VOLLMER ROAD (BARBARICK) - INTERIM CONDITION

STREET IMPROVEMENT PLAN

JULY 2023

PCD FILE NO. CDR-21-10

VOLLMER ROAD (BARBARICK)  
- INTERIM CONDITION  
NOTES

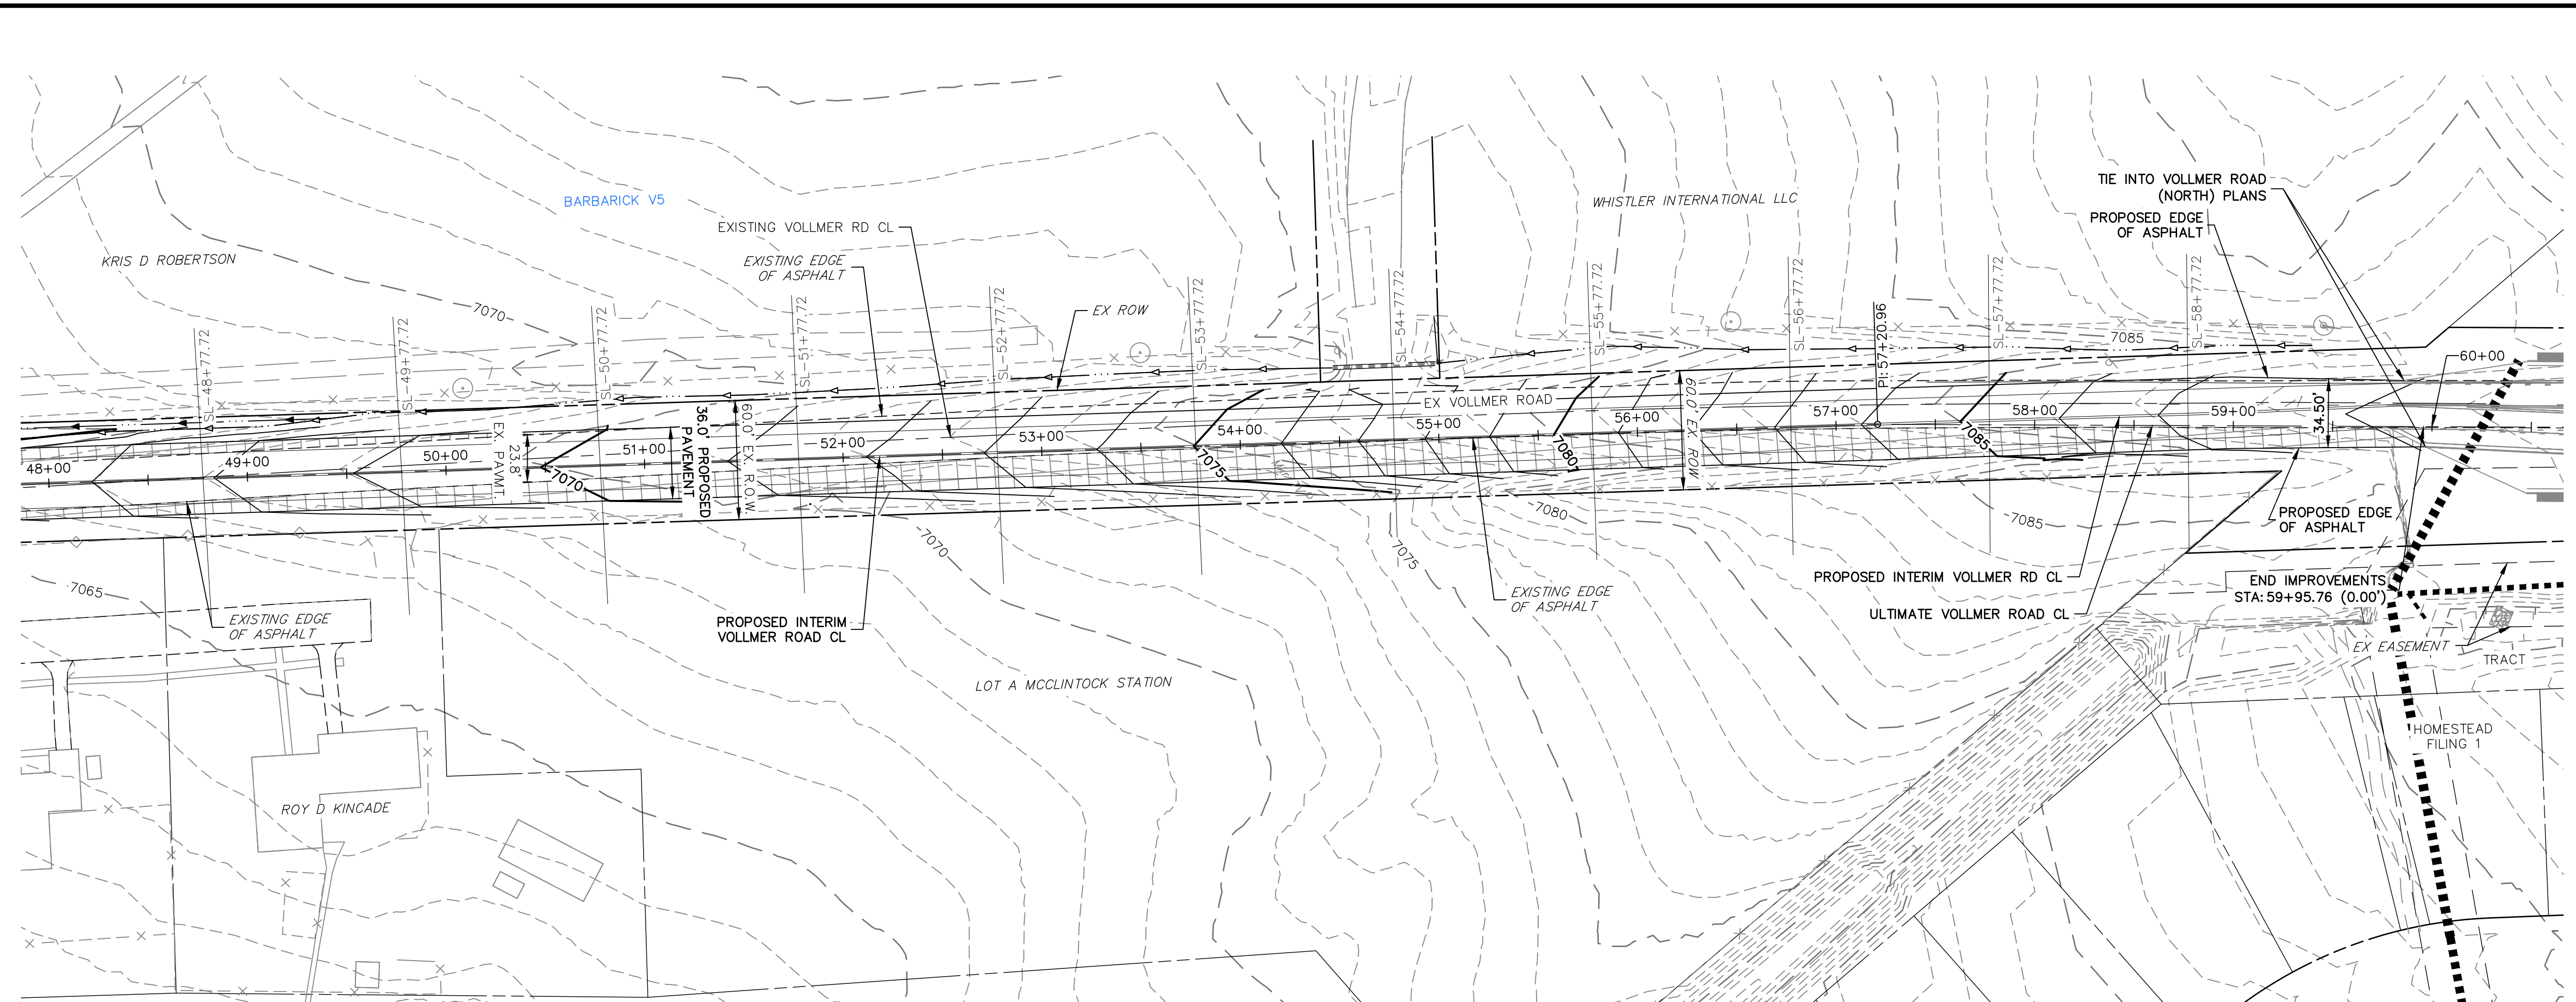
Only RCP is shown on plans.

**VOLLMER ROAD (BARBARICK) – INTERIM CONDITION**  
**CROSS SECTIONS**

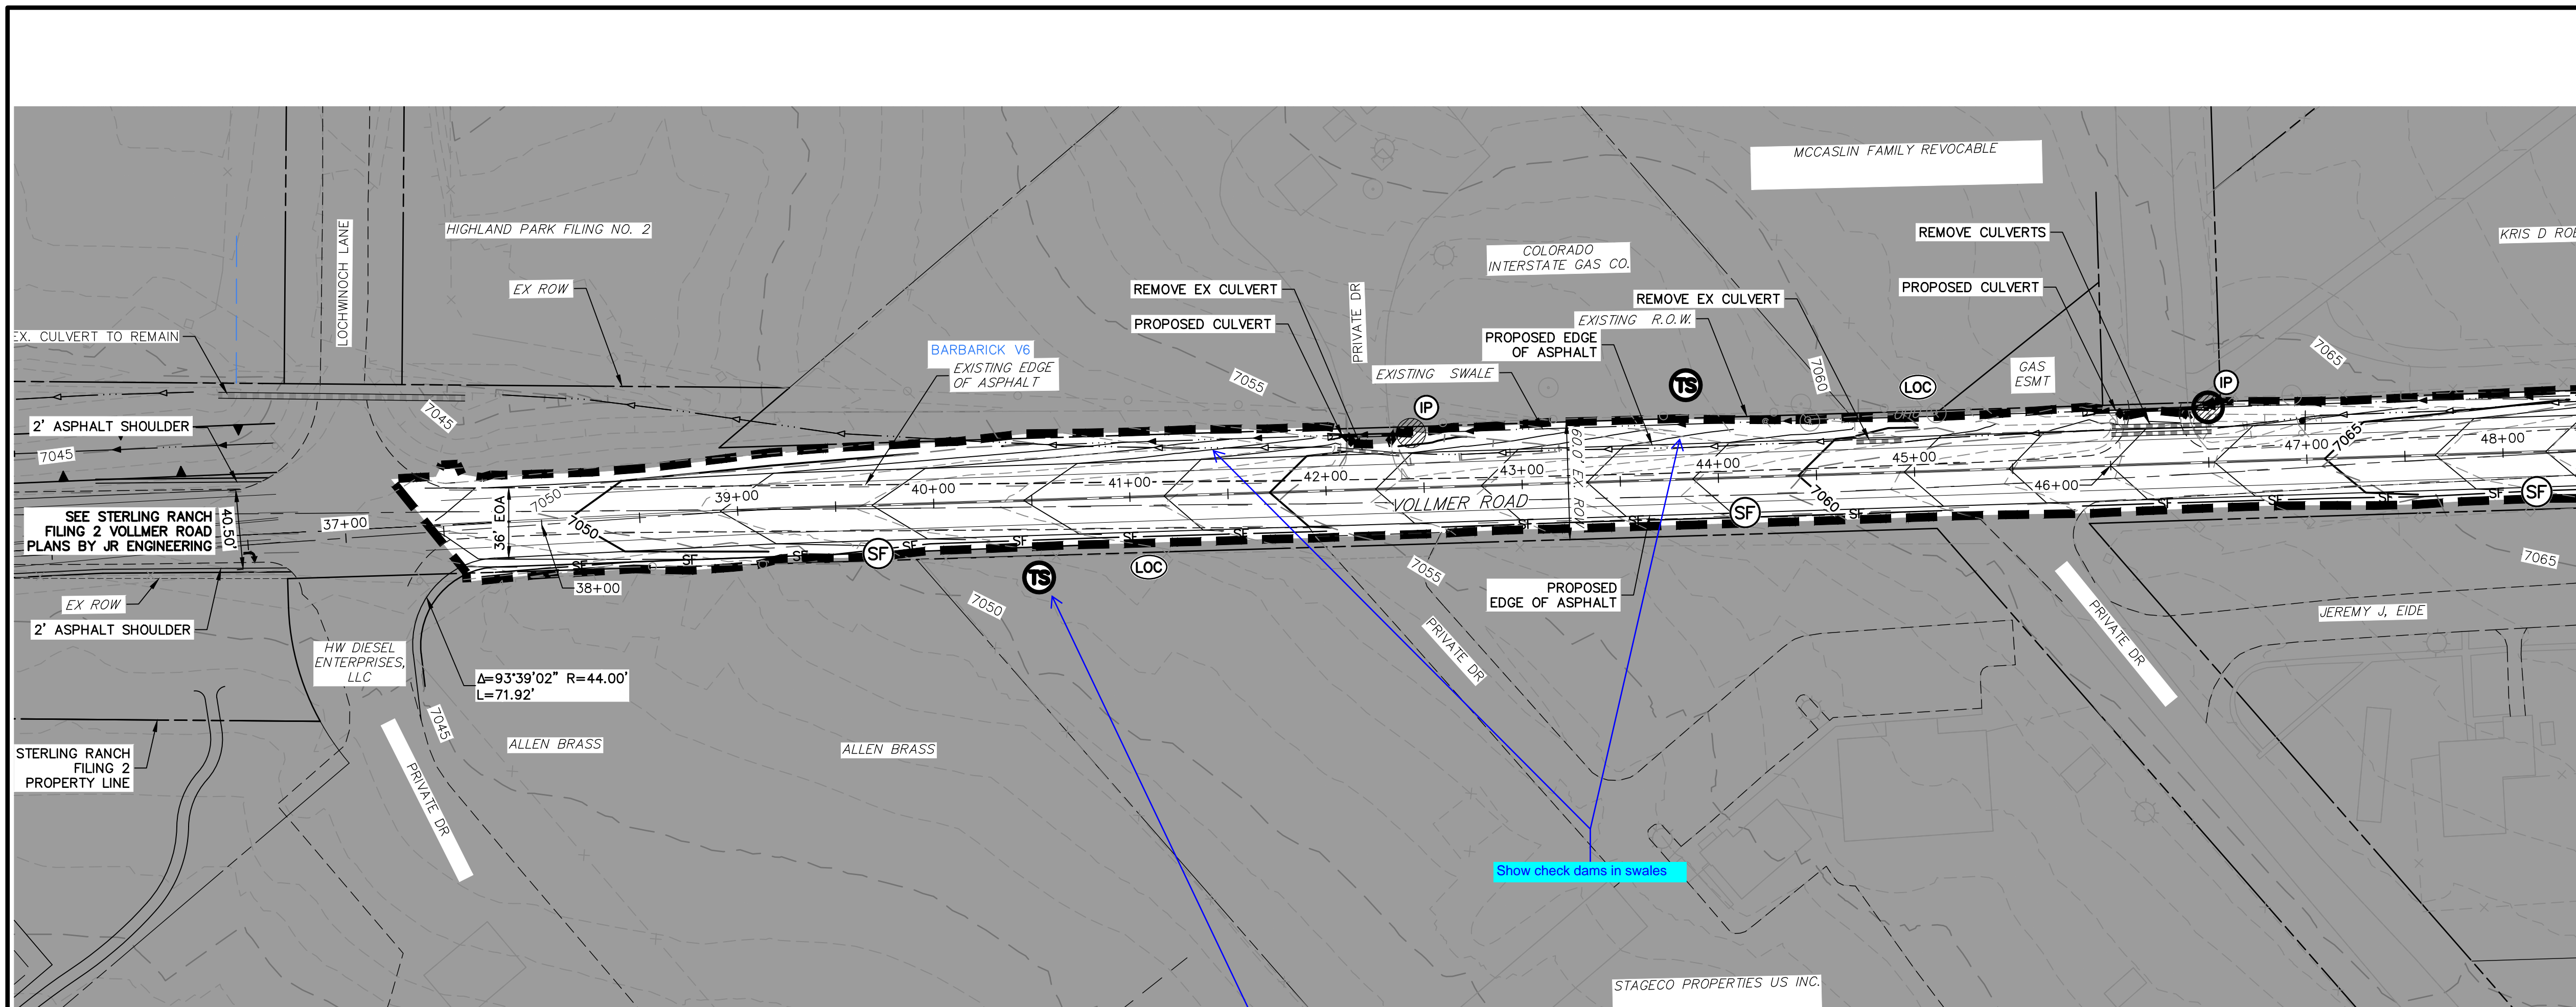
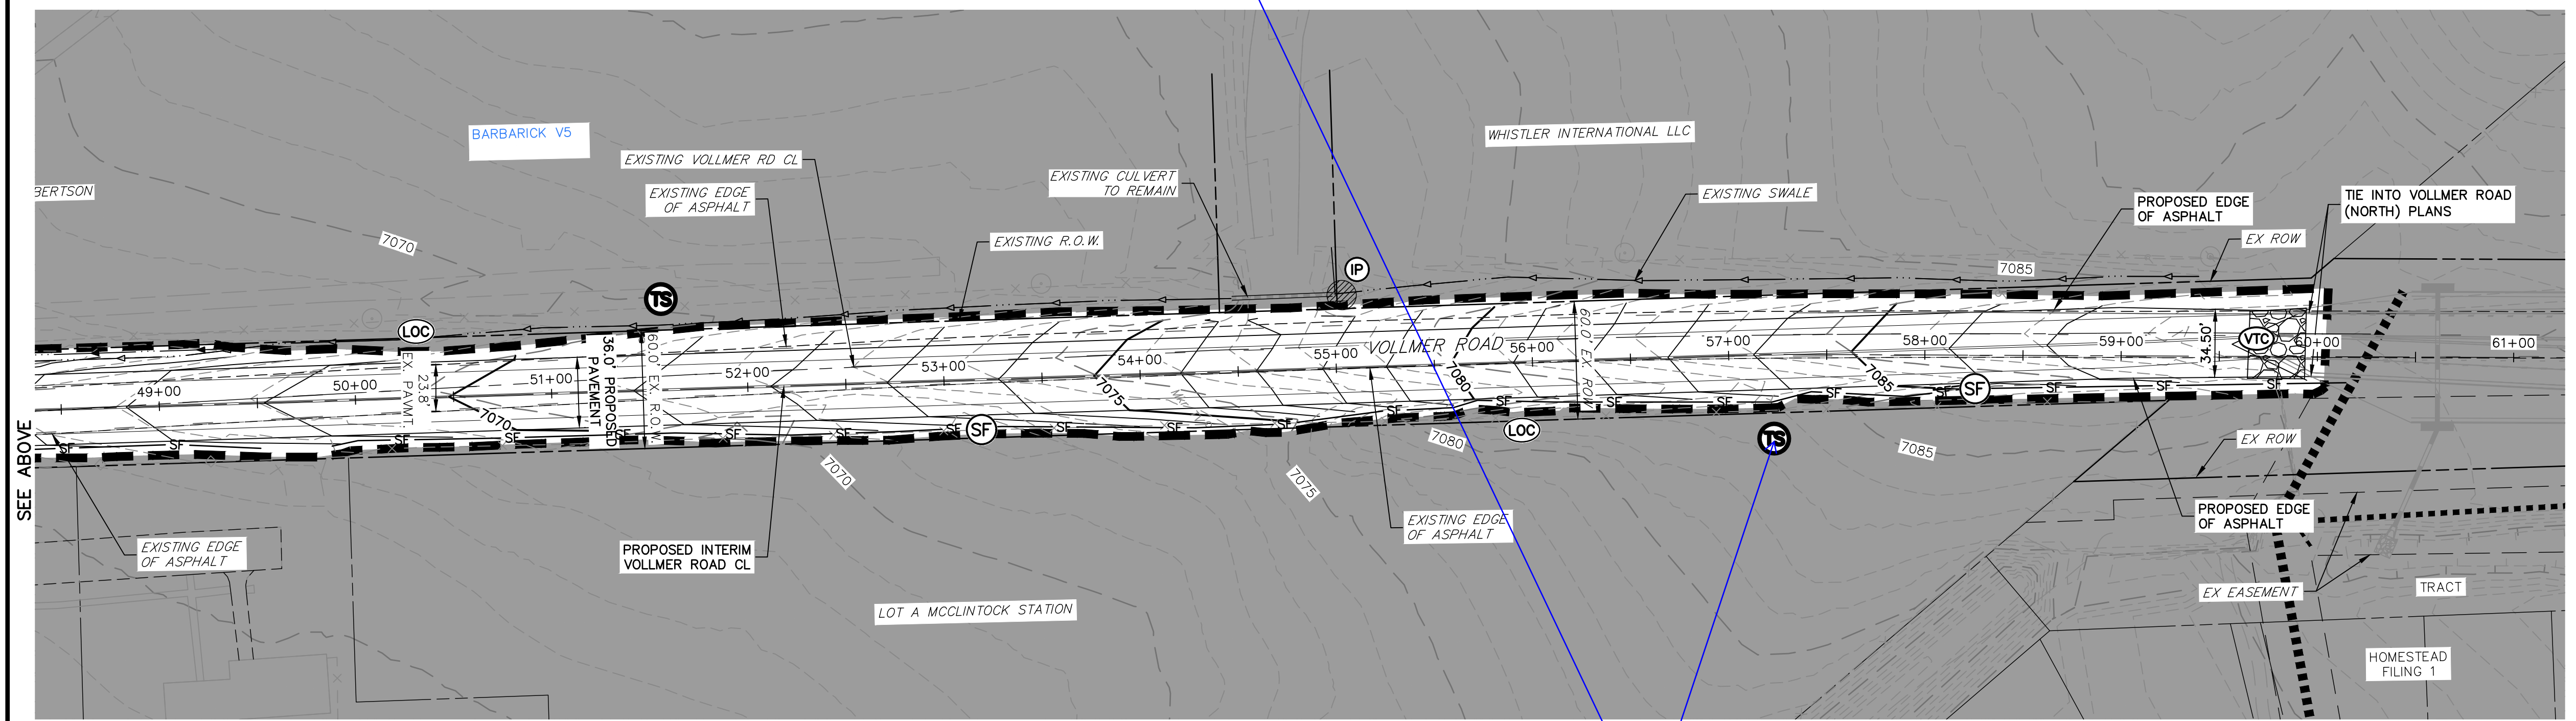
The interim cross section should show the existing roadway and the proposed widening section clearly distinguished.
